Revise to:
"SF2238"
(with no dashes or extras zeros or
extra spaces in the file number)

EL PASO COUNTY GRADING AND EROSION CONTROL PLAN CHECKLIST

File: O:\18004A-Crossroads MU-Retail\Equity Group\Dwg\Const Dwg\Grading\GR03.dwg Plotstamp: 8/1/2023 11:27 AM

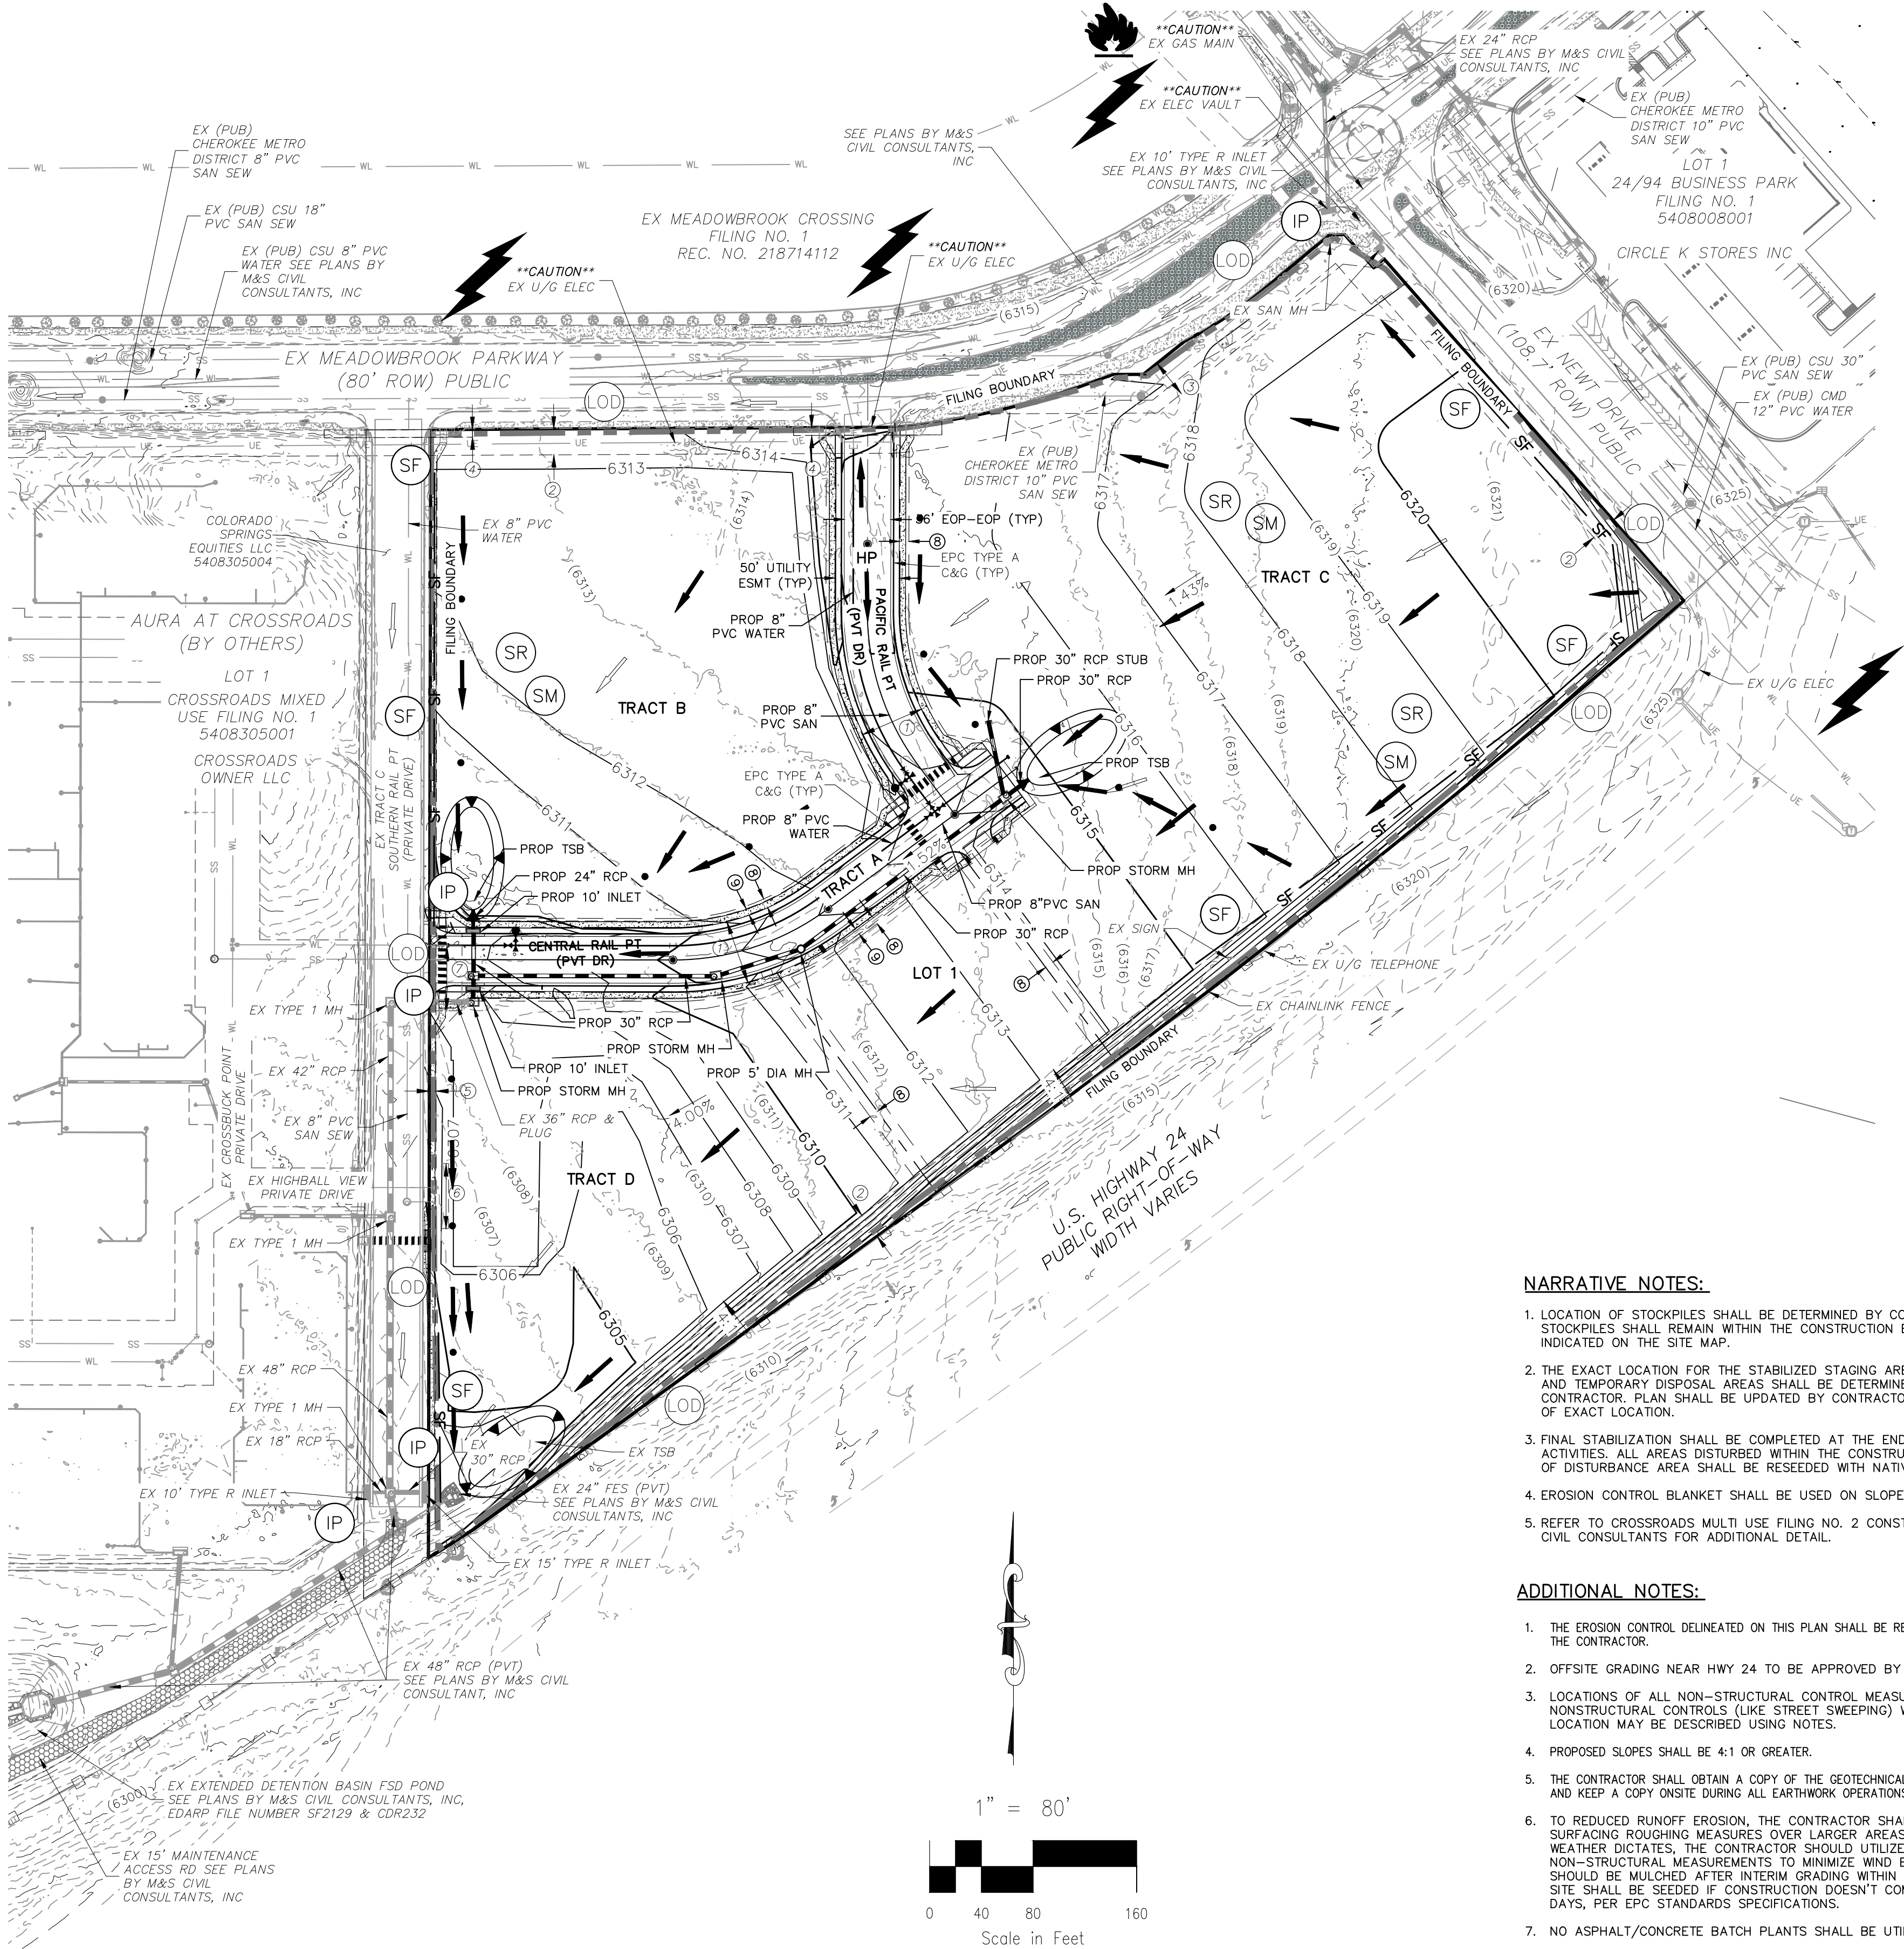
v	All proposed temporary construction control measures, structural and non-structural. Temporary construction control measures shall be identified by phase of implementation to include "initial," "interim," and "final" or shown on separate phased maps identifying each phase		Y
w	Vehicle tracking provided at all construction entrances/exits. Construction fencing, barricades, and/or signage provided at access points not to be used for construction		Y
x	Temporary sediment ponds provided for disturbed drainage areas greater than 1 acre		N

See comment on sheet GR03

Item "w" has been addressed and VTC has been added to all entrances. Item "x" has been addressed and TSBs have been added in the initial phase, as per Filing No.1.
